New England Solar Farm (SSD-9255)
Upgrade of New England Highway & Barleyfields Road (north) intersection

UPC\AC Renewables Australia (**UPC**) is requesting the NSW Department of Planning, Industry, and Environment (**DPIE**) to approve a variation to the treatment of this intersection from CHR to a Shortened Channelised Right Turn (CHR-S). Schedule 3 Condition 4 of the New England Solar Farm Development Consent permits the Secretary to vary the road upgrade requirements.

¹ Refer to the figure in Appendix 4 for the location and further details of the road upgrades.

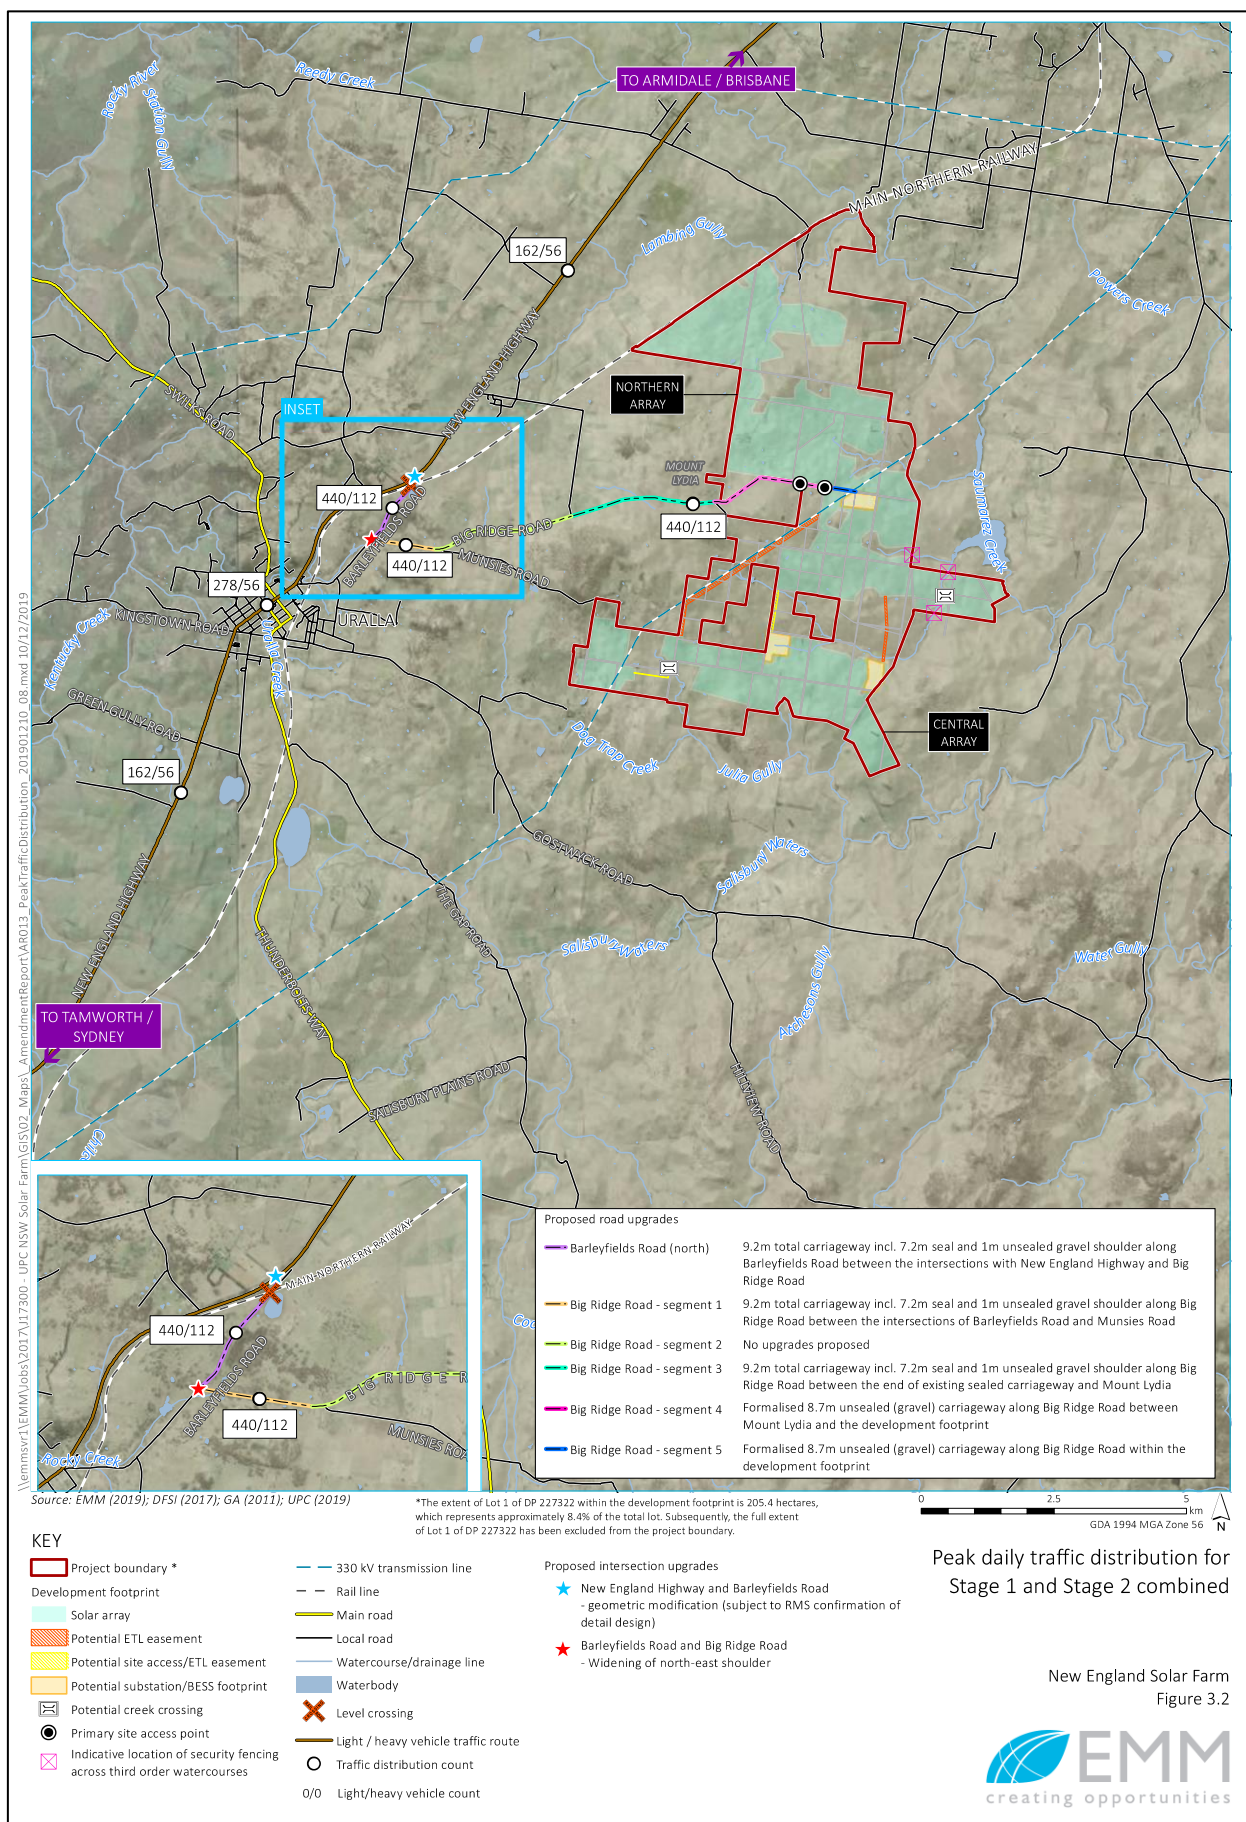
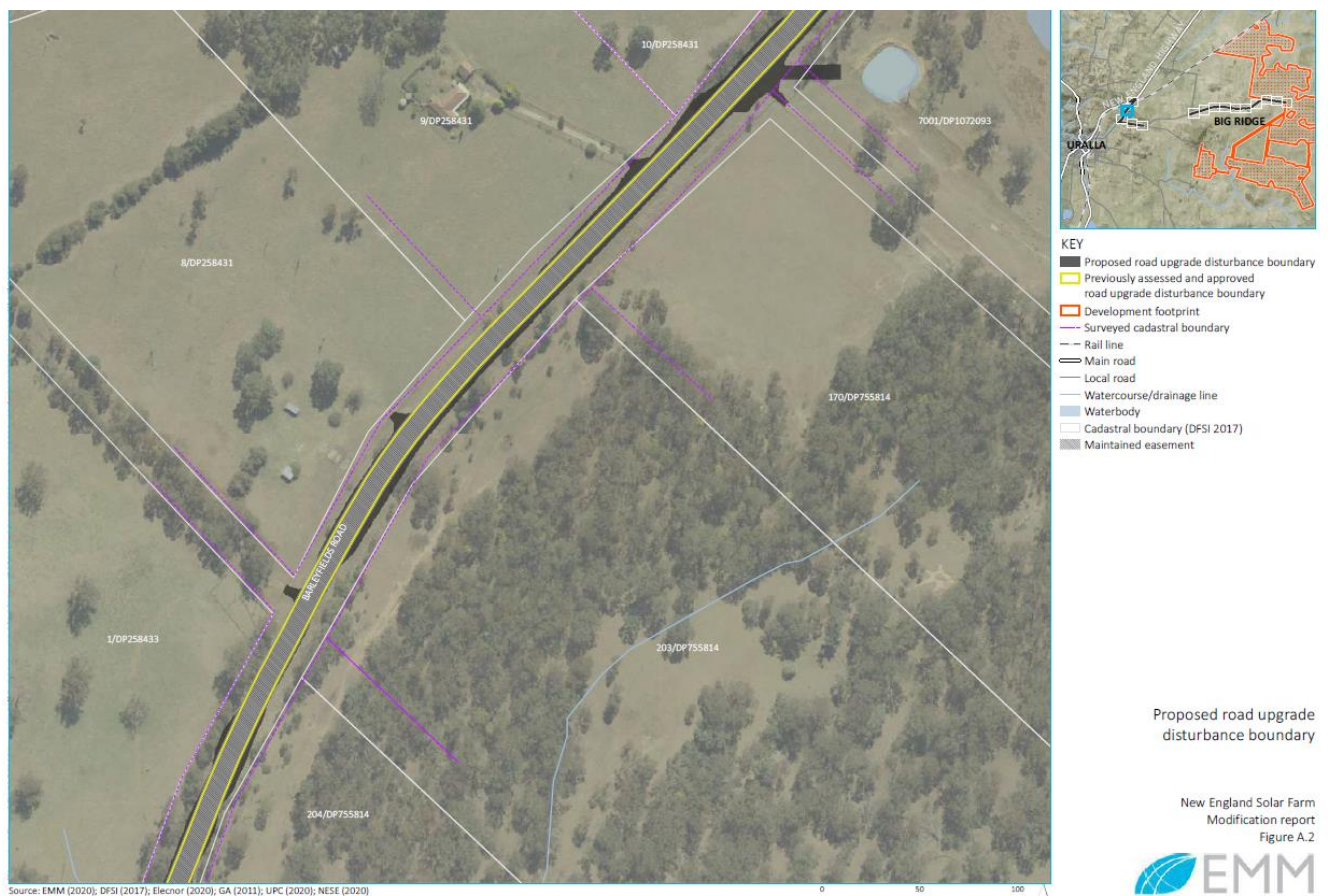
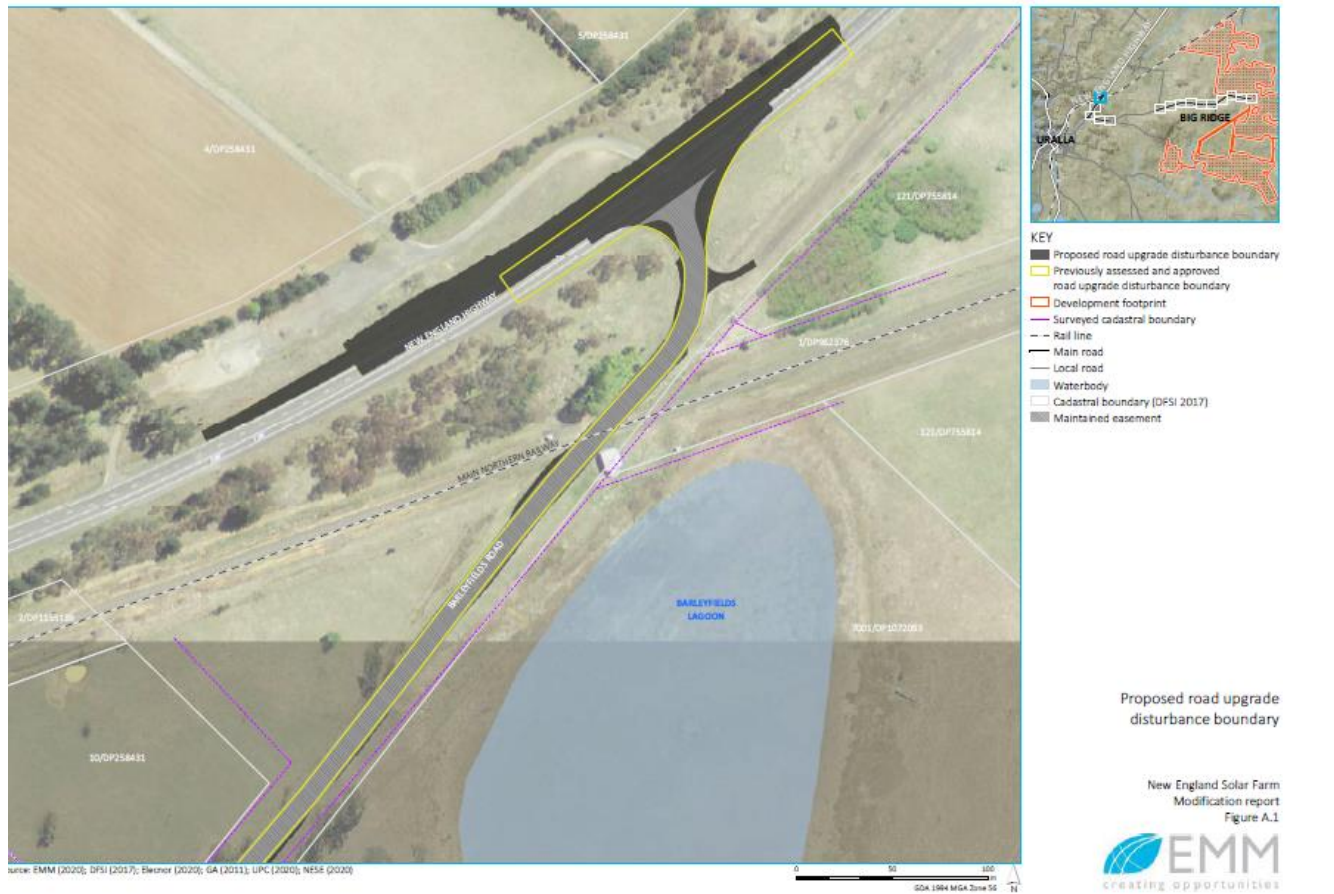
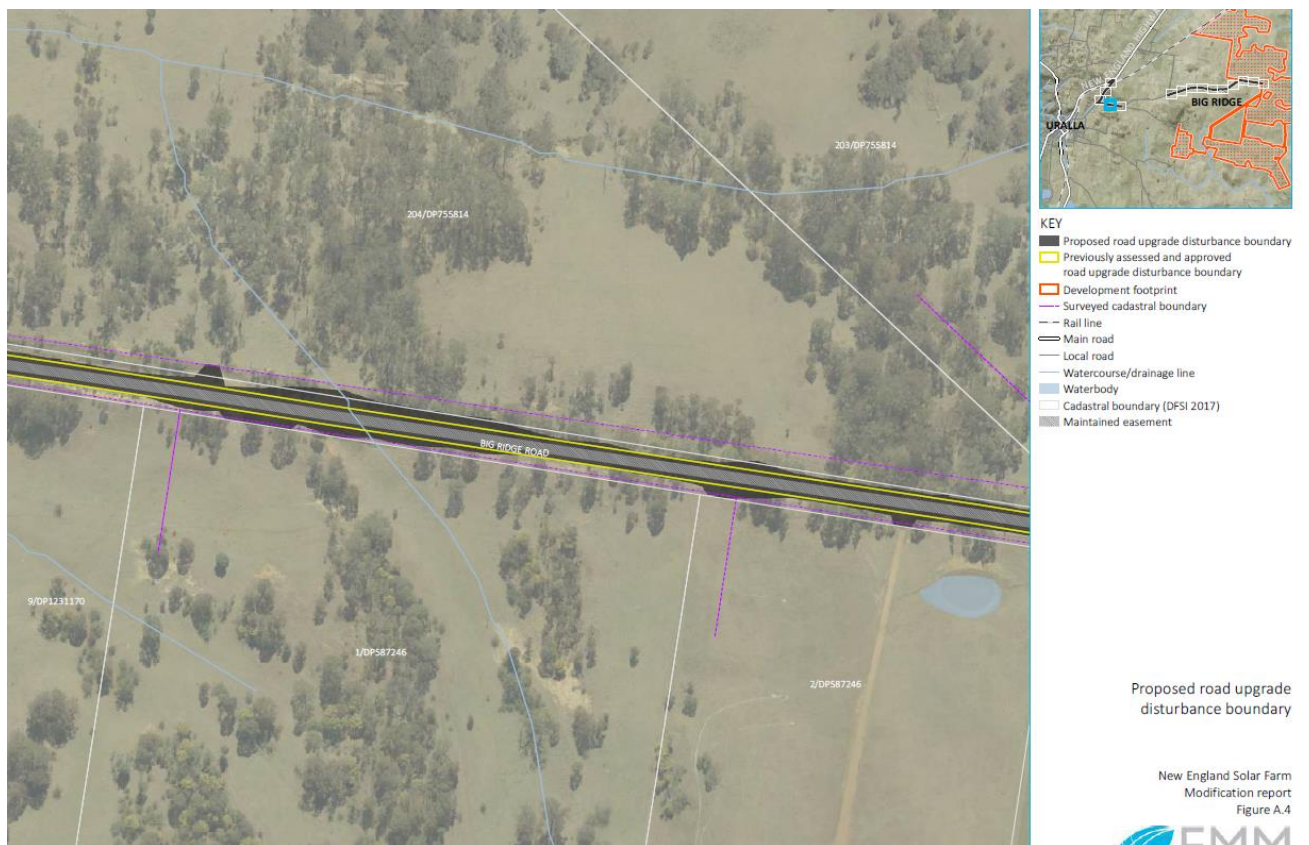
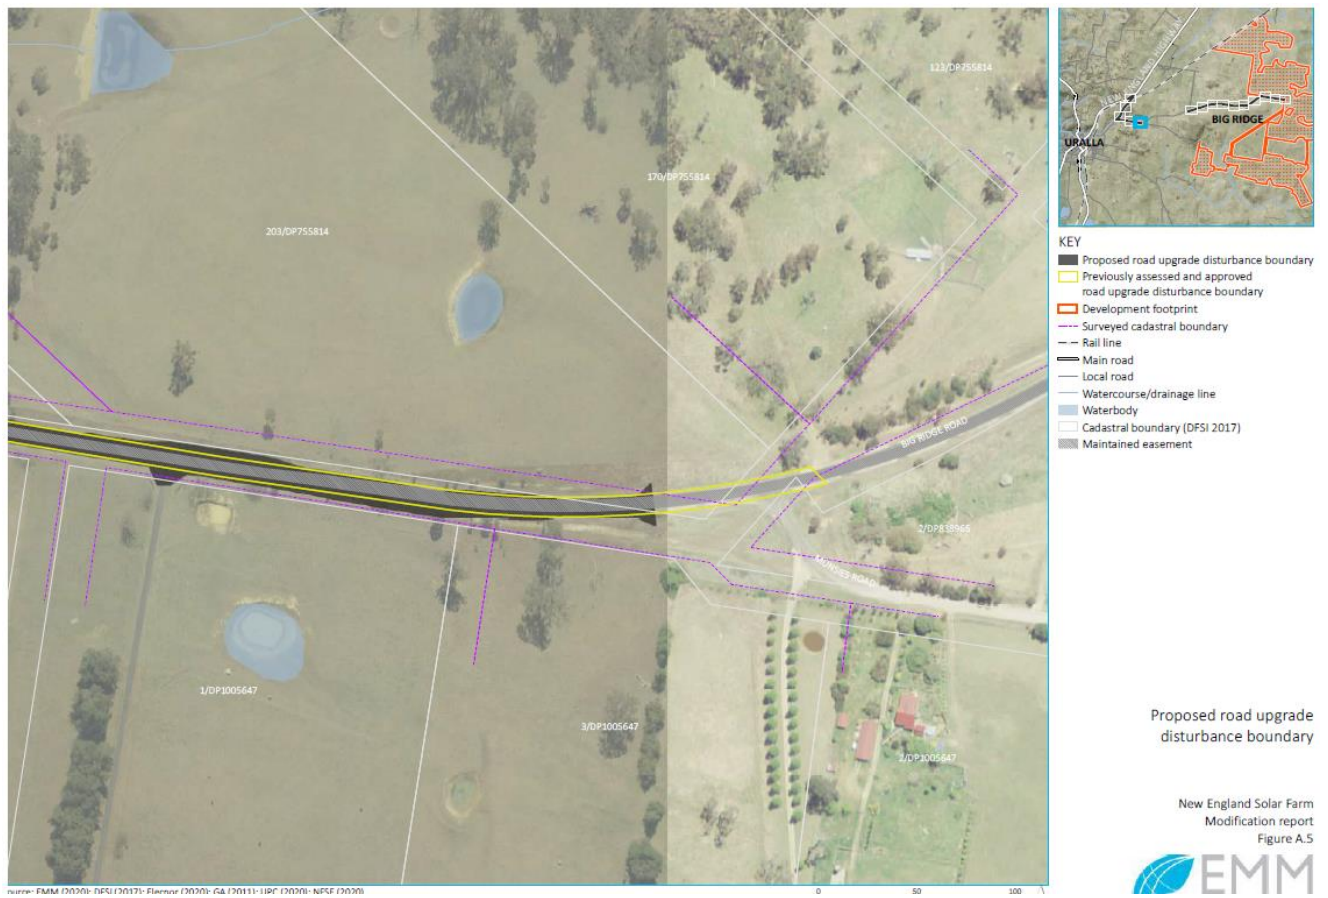
1. The CHR-S is the appropriate treatment of the intersection based on current and forecast traffic volumes (excluding construction traffic) (refer TfNSW letter in Attachment A)
2. Construction traffic could be managed through appropriate safety measures to be documented in the conditioned Traffic Management Plan
3. A CHR intersection would reduce the length of the northbound overtaking lane leaving Uralla, which was not preferred by TfNSW (refer TfNSW letter in Attachment A).

With consideration to the above, we seek approval for the proposed CHR-S treatment of the intersection.
